AH/220010/L0004

18th March 2022

**On behalf of Kier PGIM Logistics Propco 1 Limited, Saltbox, Bognor Regis:
Non-material amendment to planning permission BE/135/18/PL (as previously amended by
BE/125/21/NMA) - Alterations to approved external appearance and roof of Units 6 & 7**

Drg No KP-281-Units 6/7-NMA-01

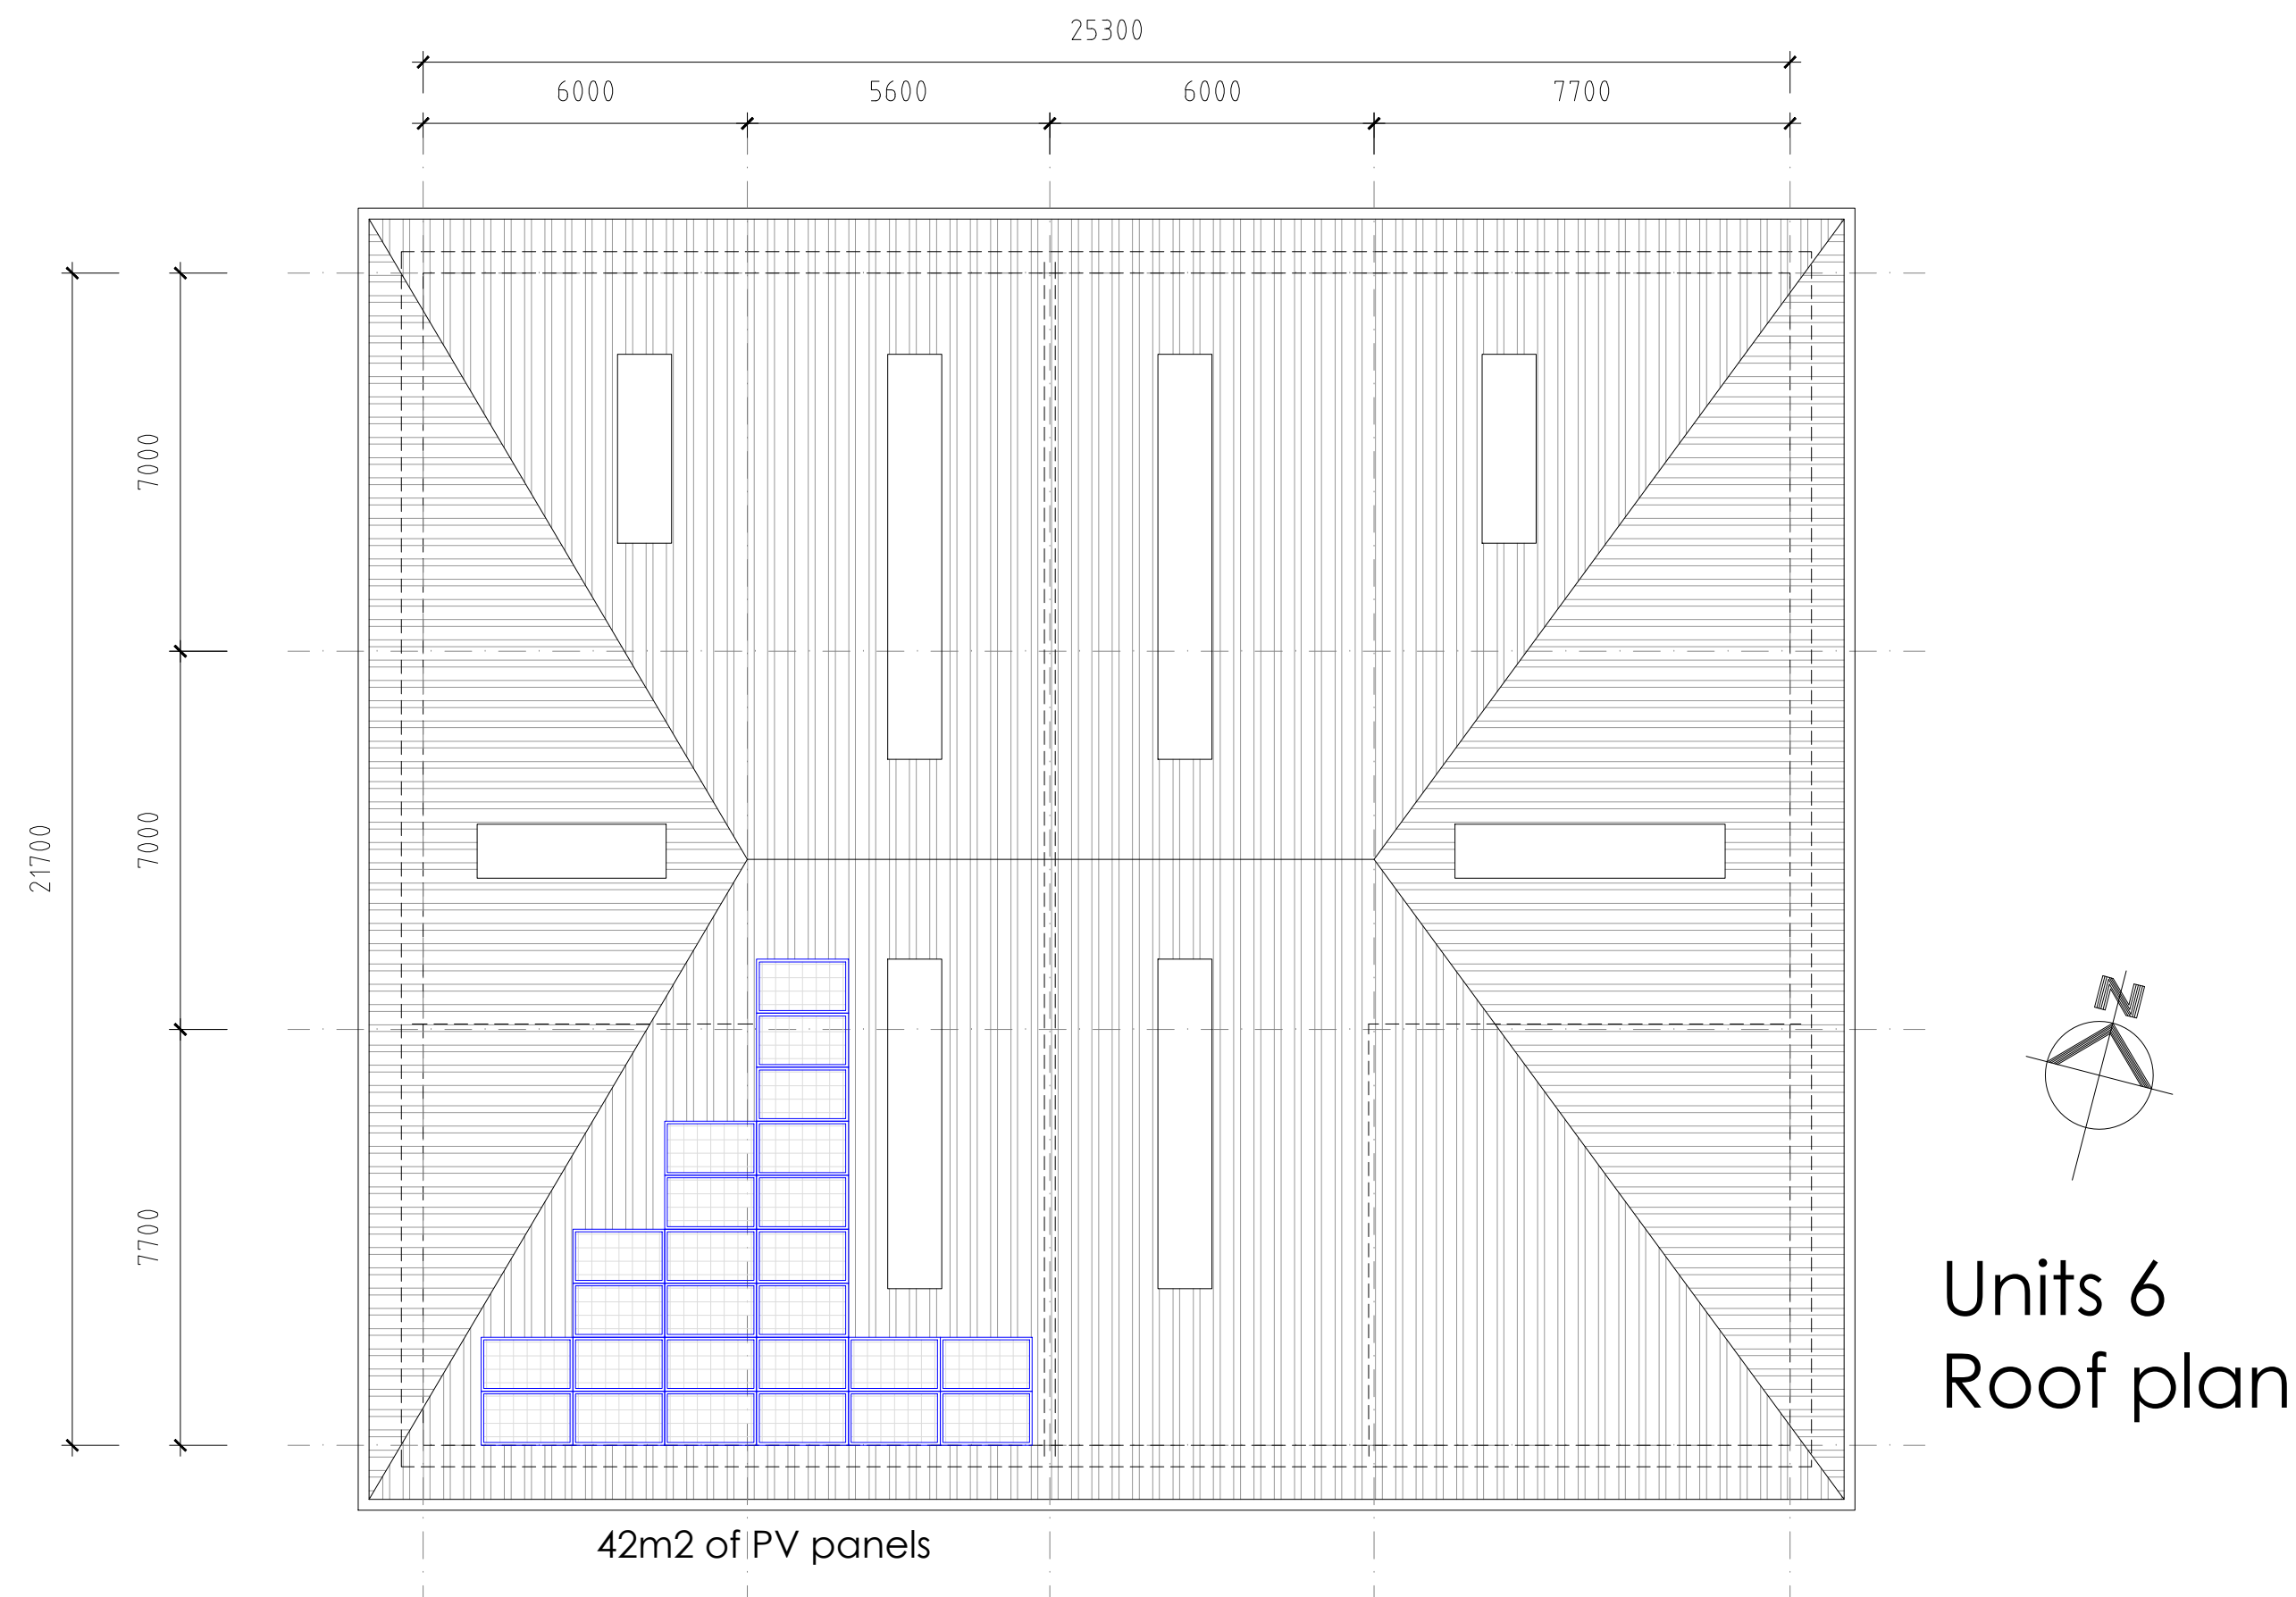
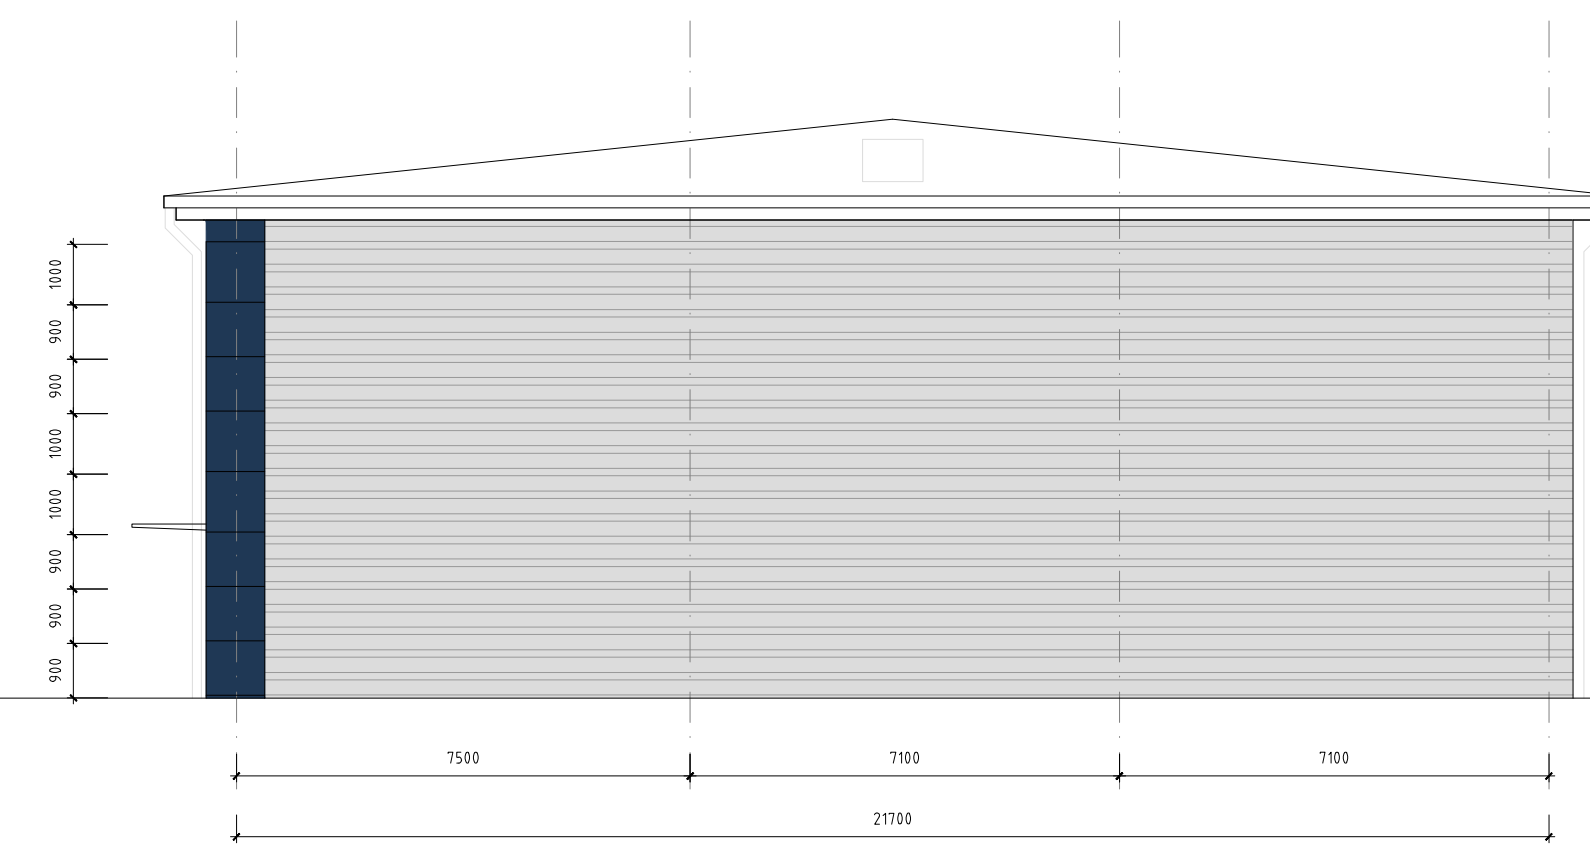
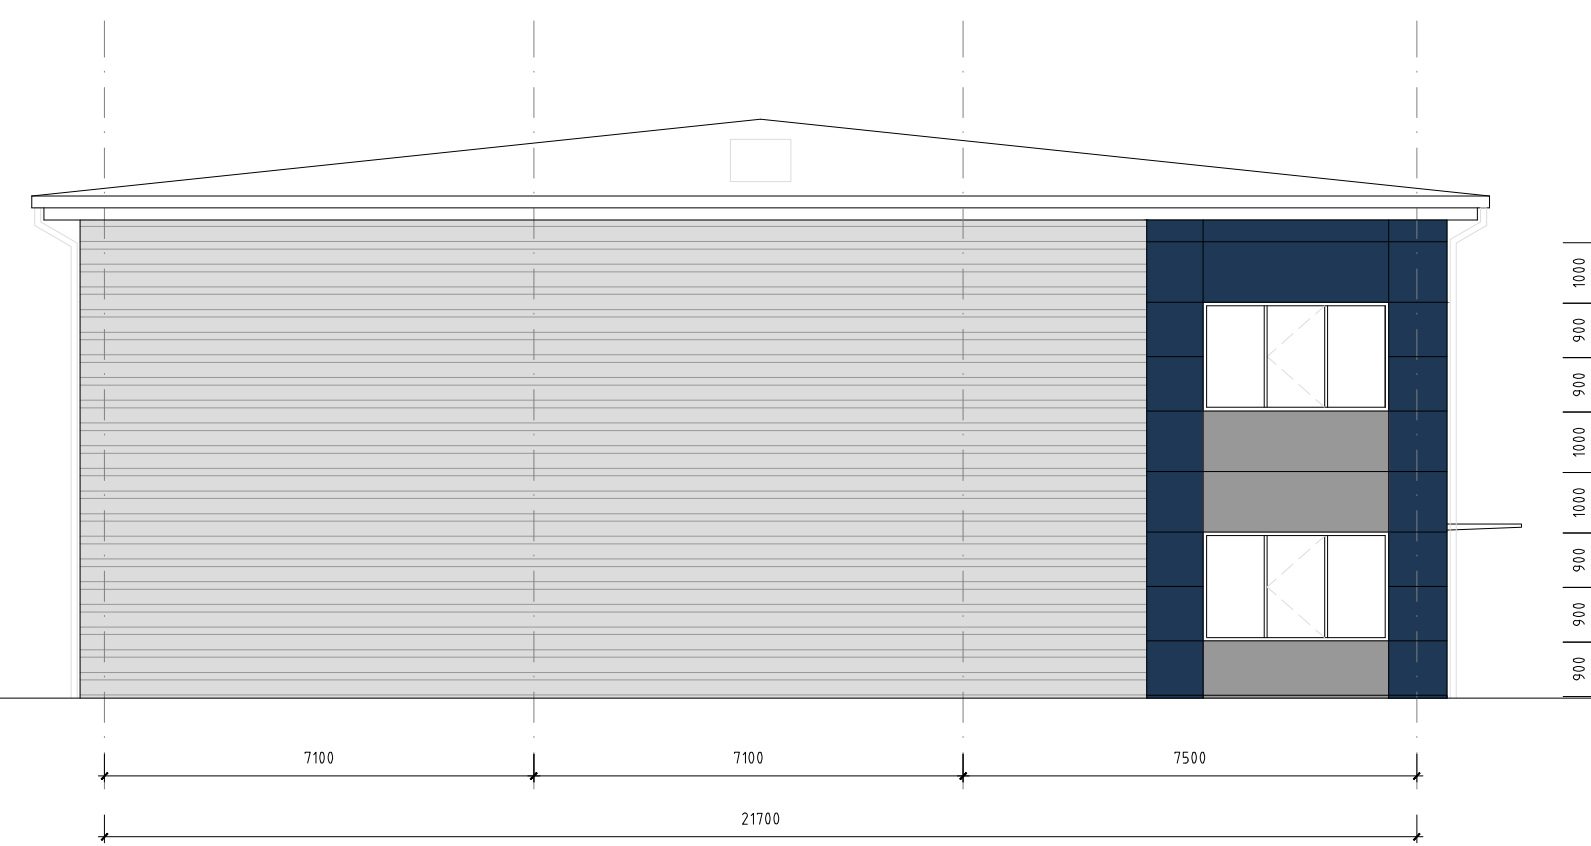
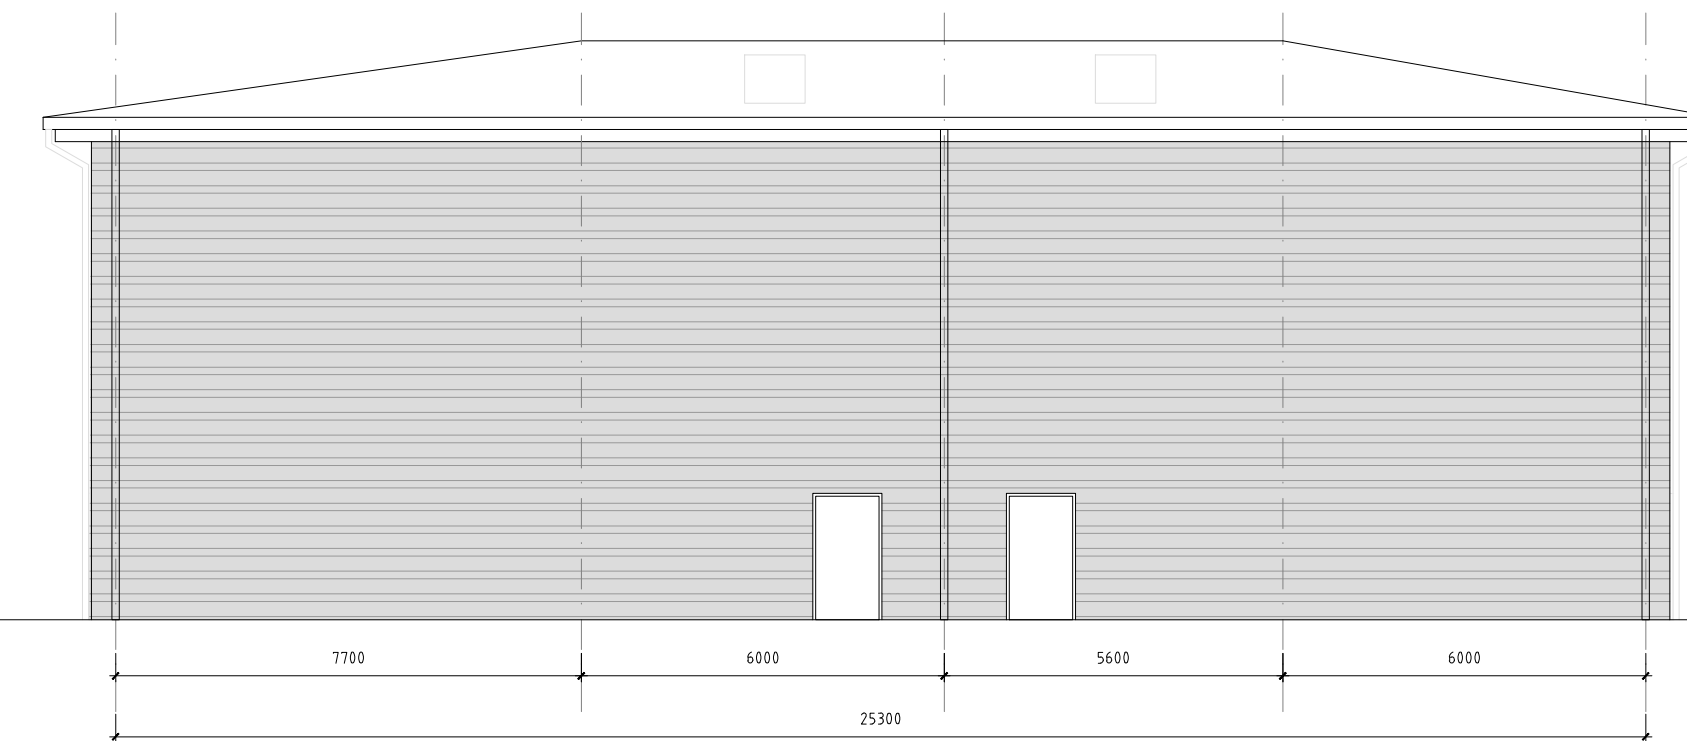
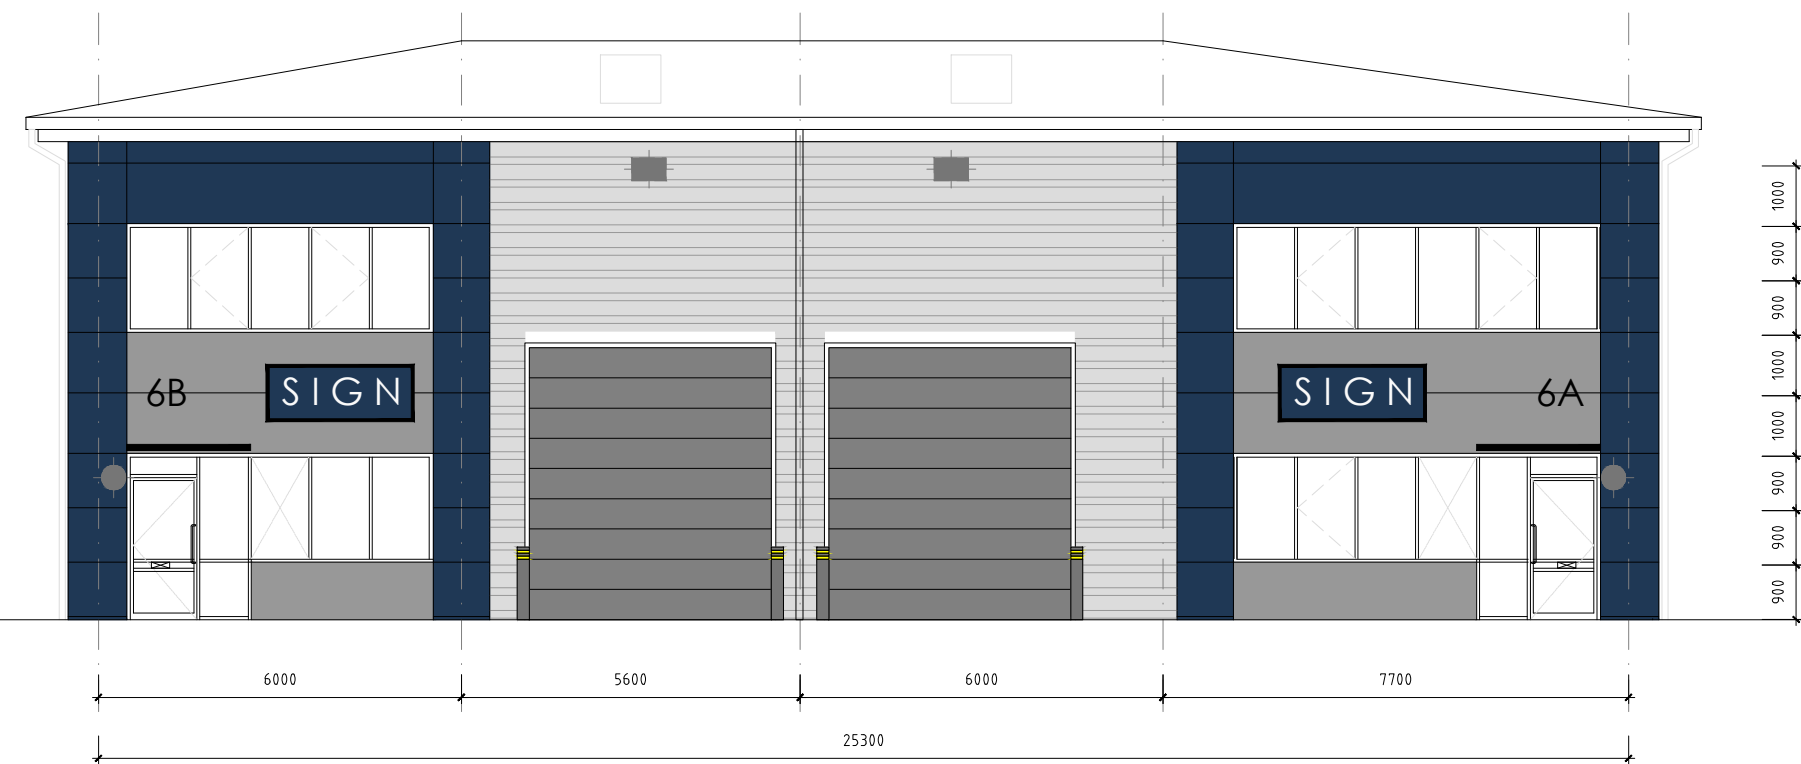
The detail of the change sought is shown on the enclosed drawing KP281-Units 6/7-NMA-02 prepared by Ian King Associates. This shows revisions to the elevations of Unit 3 in response to the requirements of the intended tenant and changes to the associated materials to correspond with Kier's specification for the site.

A minor change is also proposed to the roof to incorporate hip features at the western and eastern ends. This will add interest to the building's appearance and will also serve to reduce its overall scale and massing.
